Application for Removal or Variation of a Condition following Grant of Planning Permission or Listed Building Consent

Internal Alterations, Two Storey Side and Rear Extension Attic
Conversion including Dormer to Rear, and Rendering of First
Floor Front Elevation

23/00450/FHA

Change in materials new drawings below -
22011 AL (0) 110D
22011 AL (0) 111D
22011 AL (0) 120D

[PROJECT]	Alterations + Extension to 2 Ridgeway Berkhamsted
[DRAWING]	PROPOSED ELEVATIONS SECTION
[SCALE]	[CHECKED]
1:50 @ A1	
[STATUS]	PLANNING
[NUMBER]	22011 AL (0) 120D

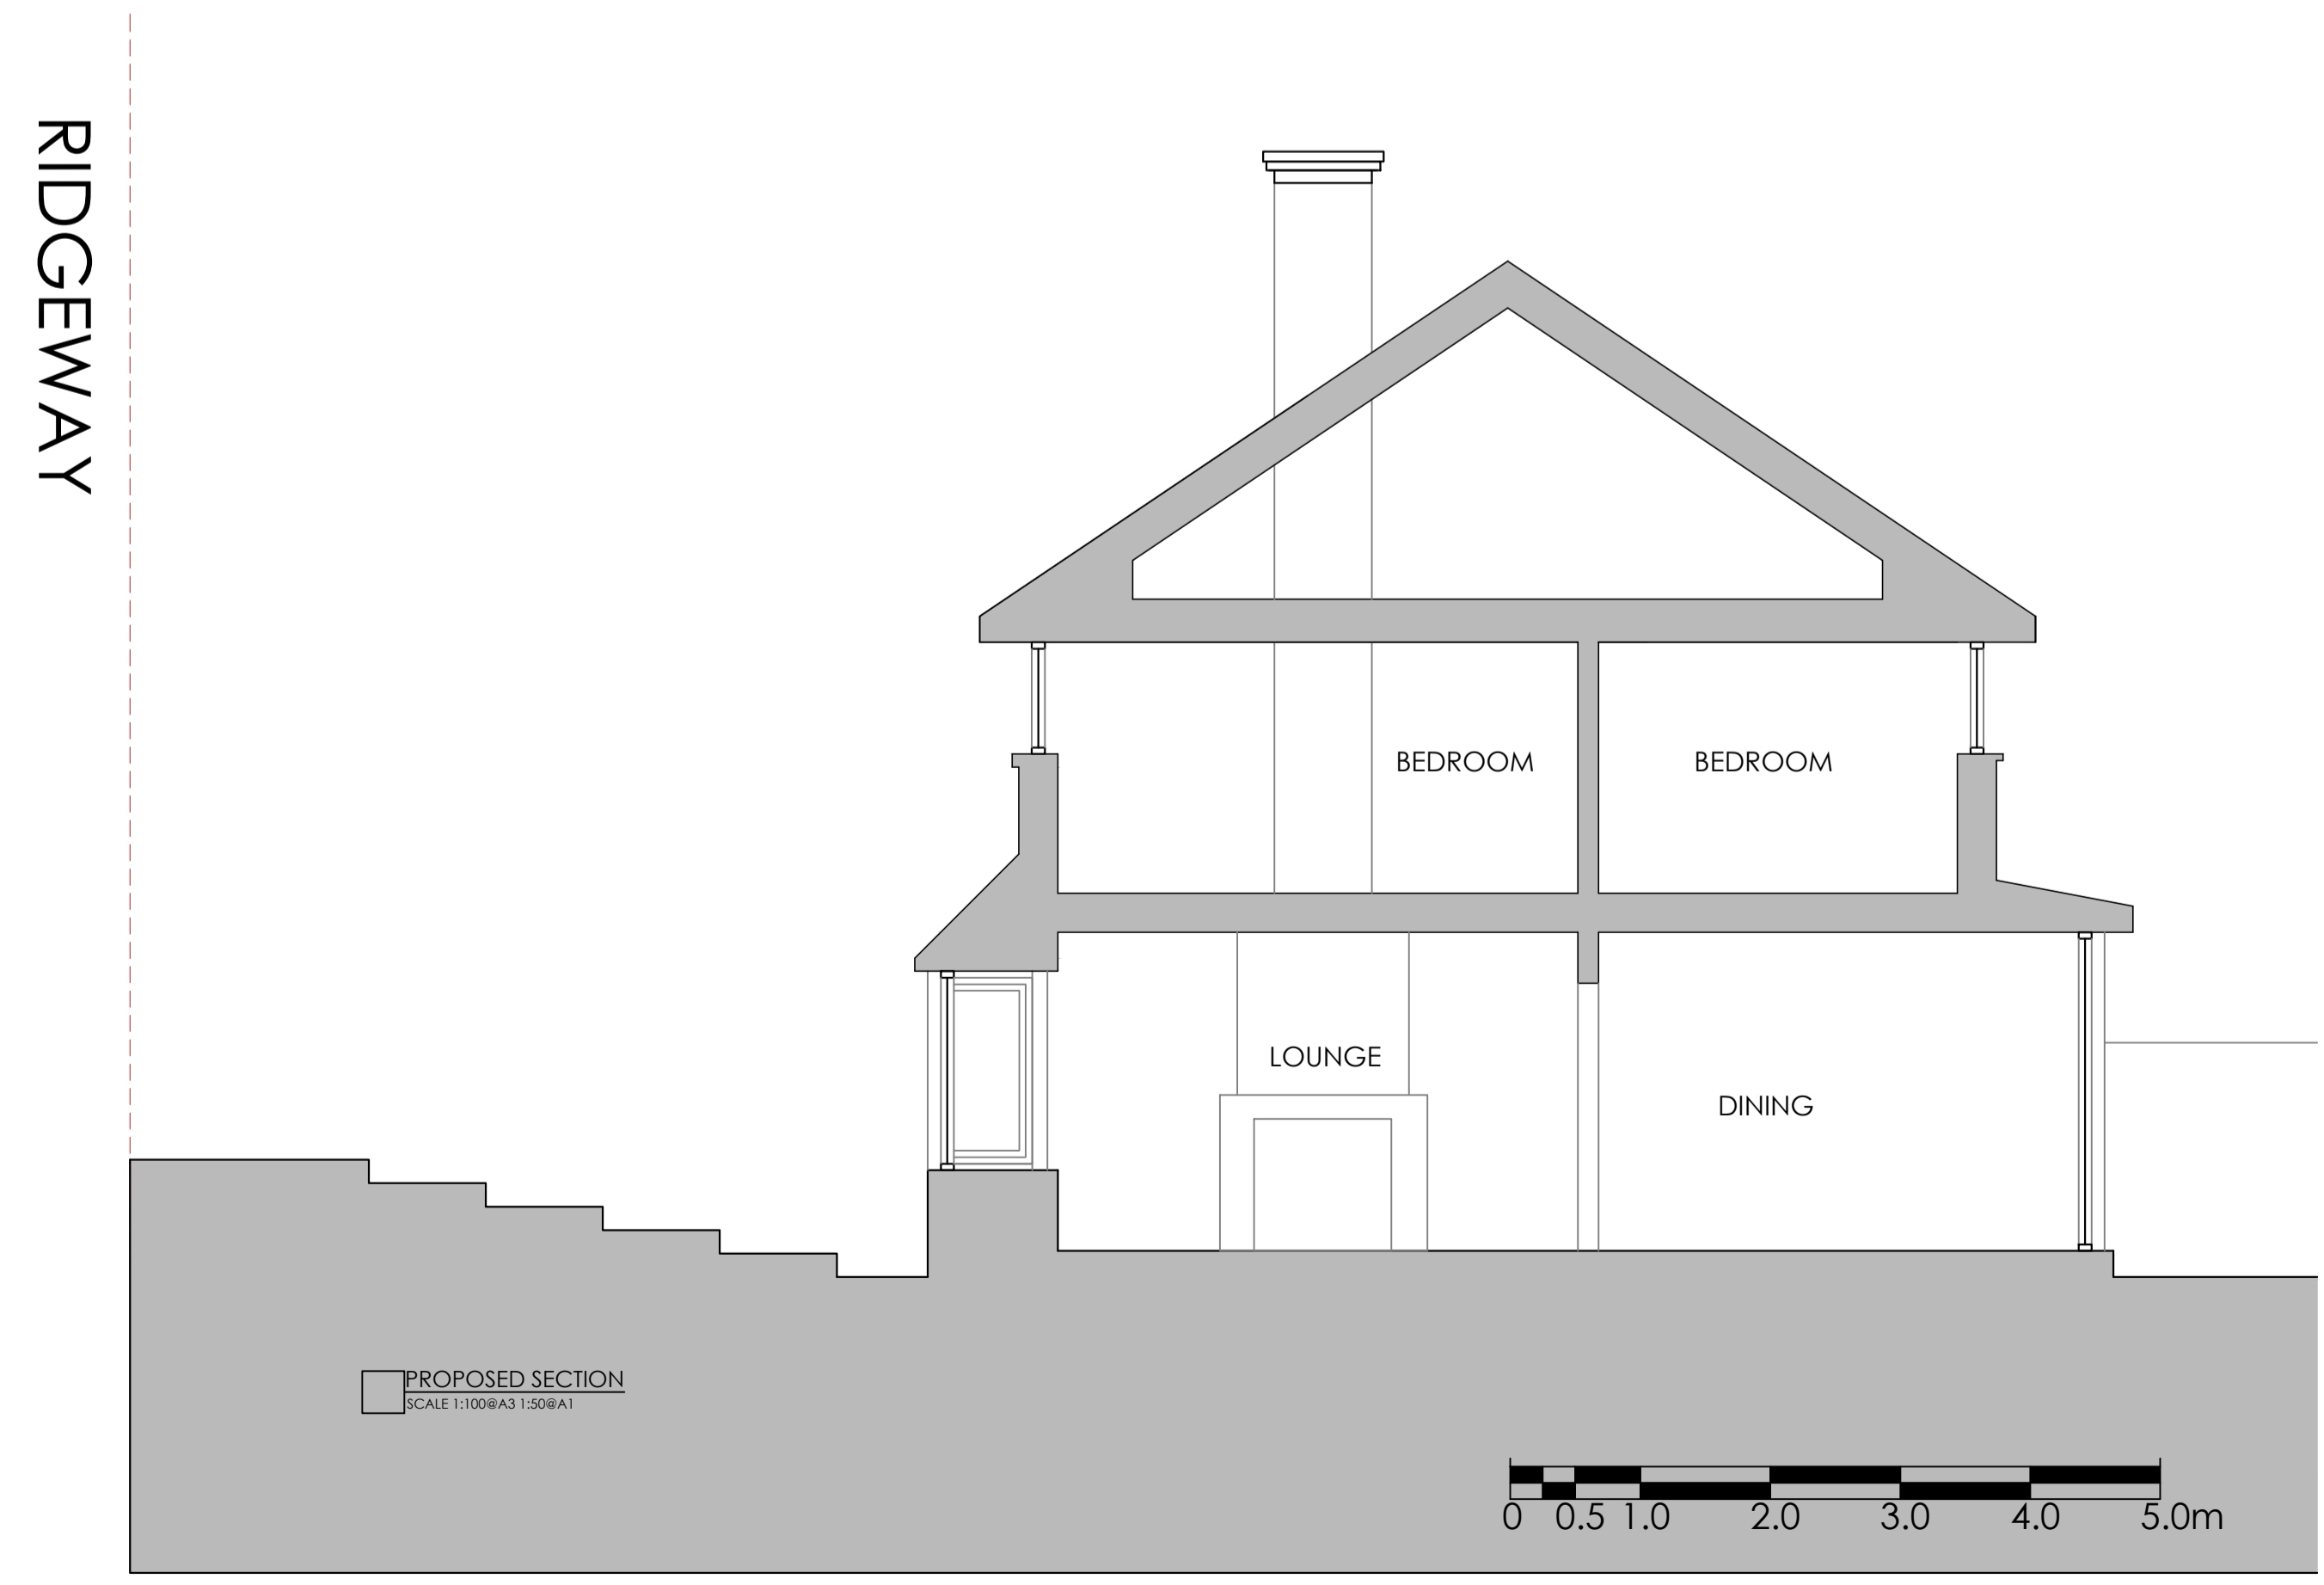
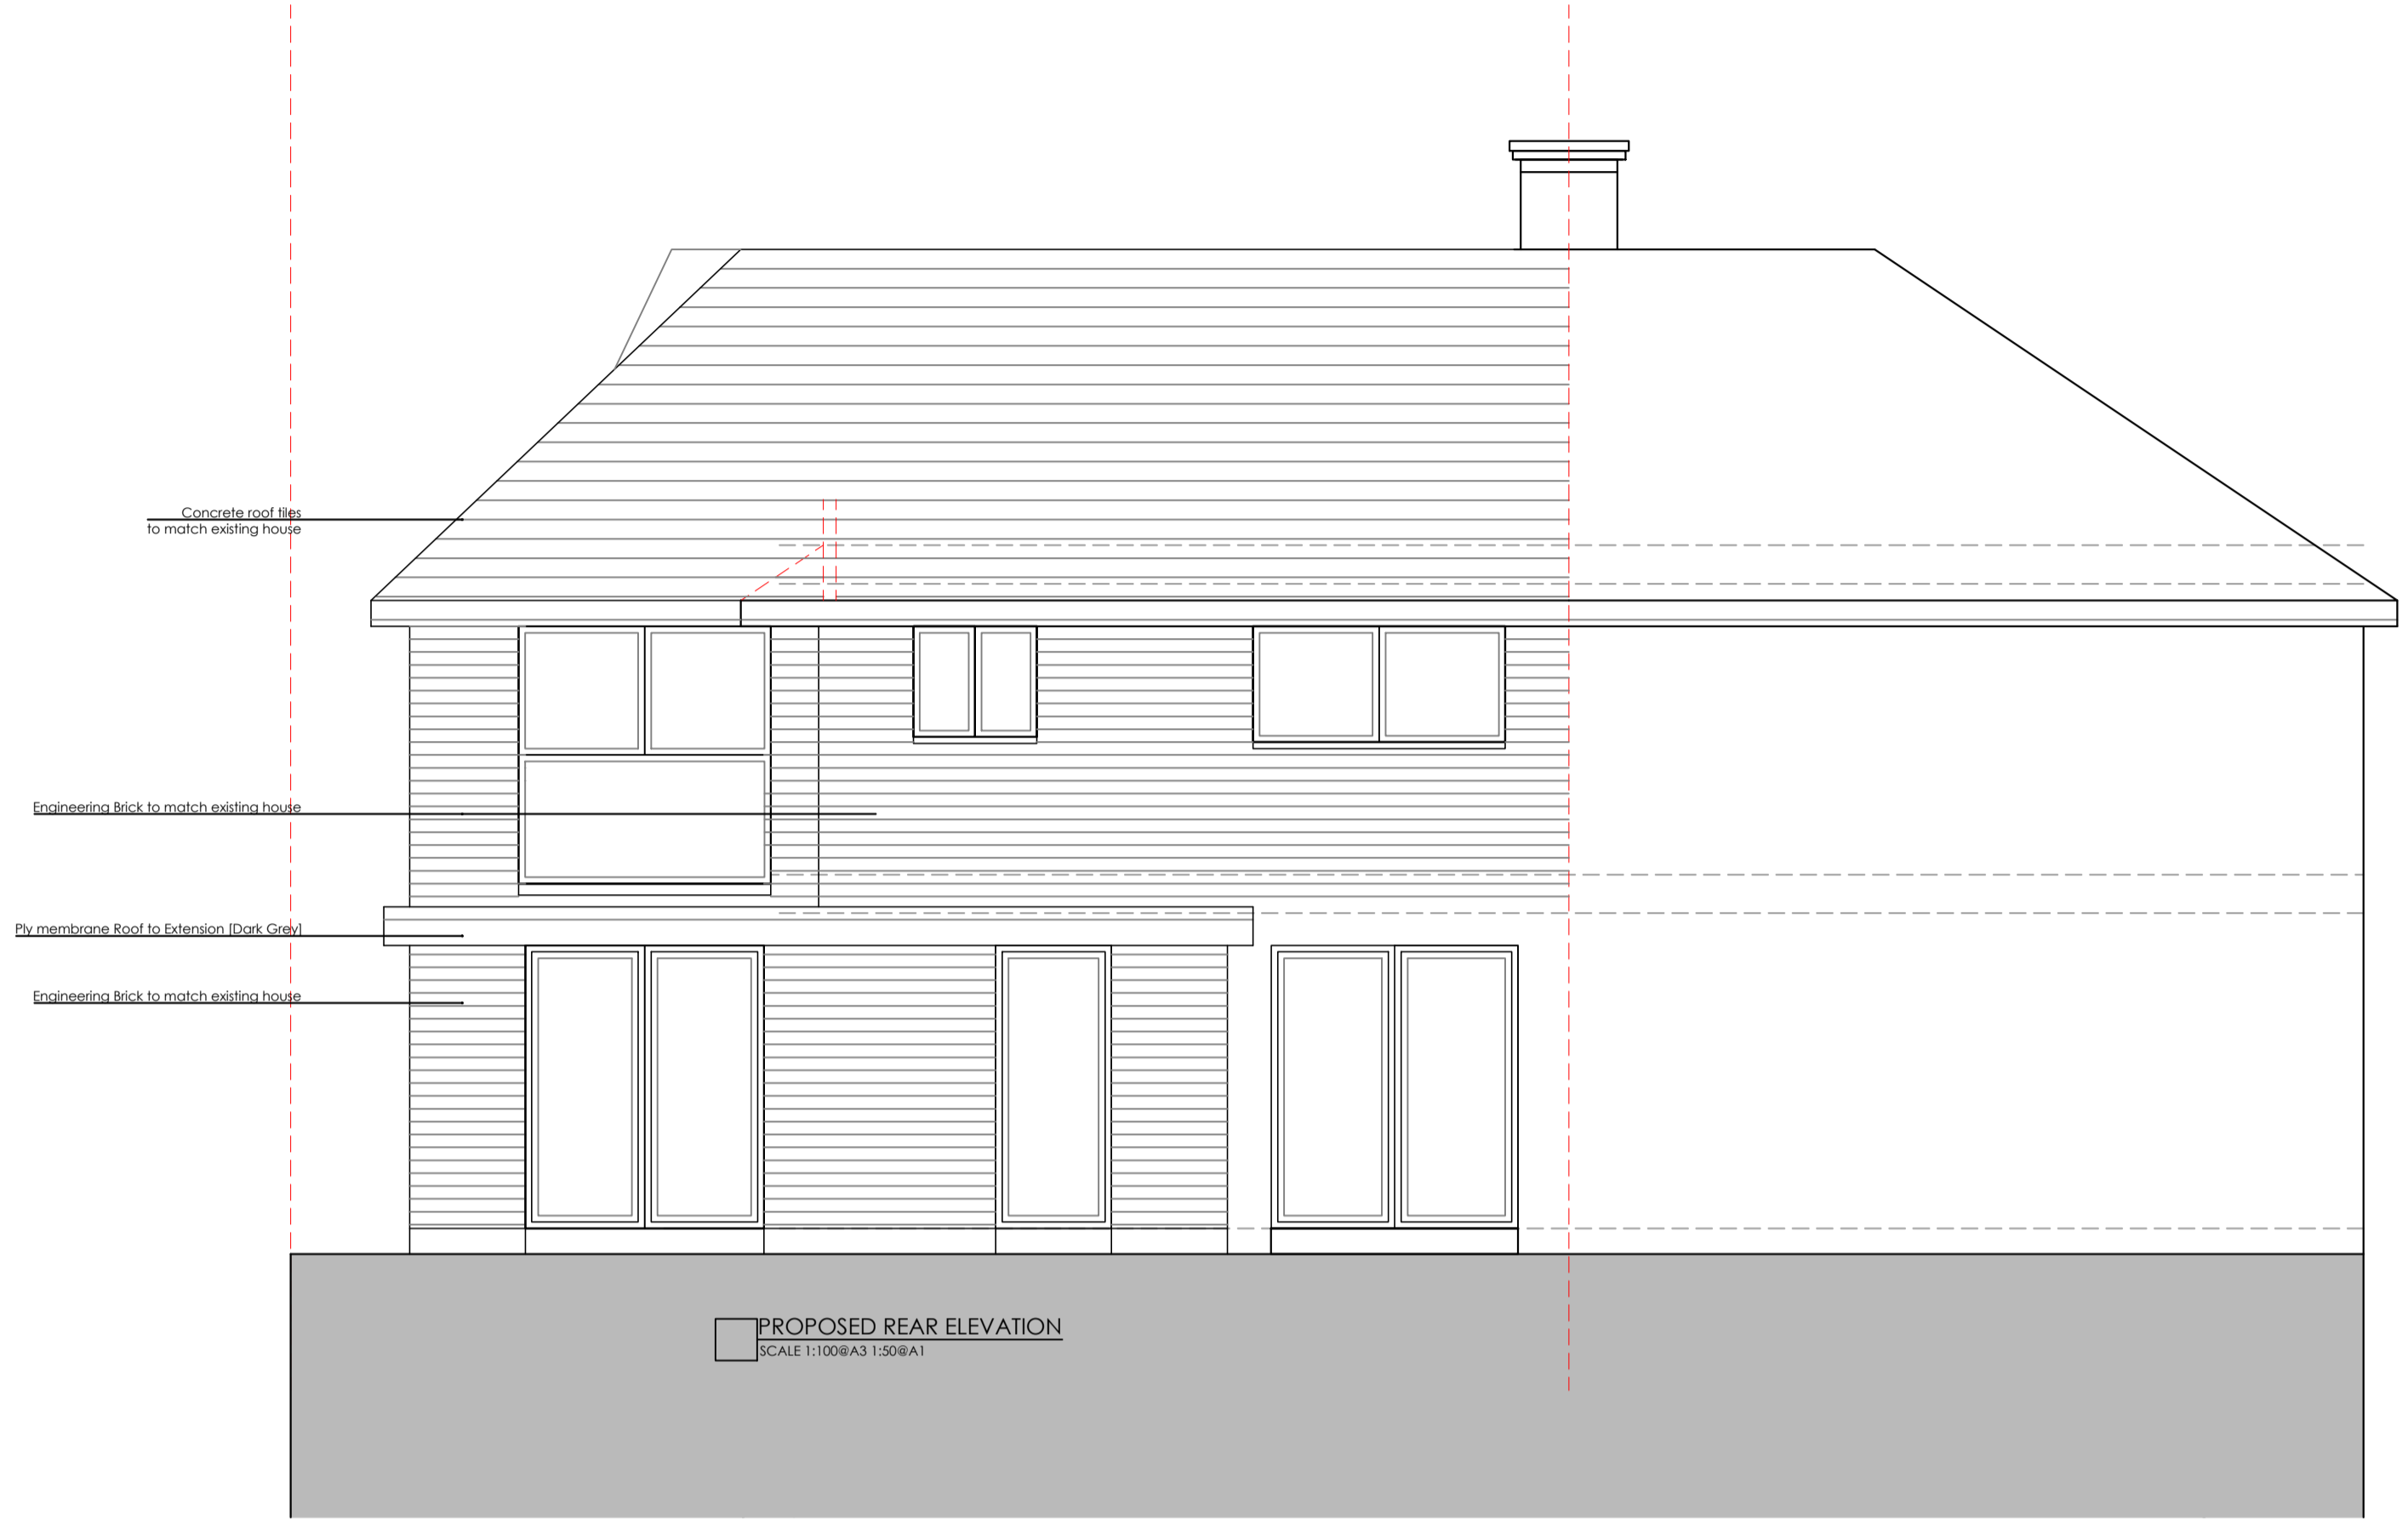
Change in Materials - omit proposed render to front / rear elevations
Omit Loft Conversion works
Omit Rear Dormer Window
Omit Velux Windows
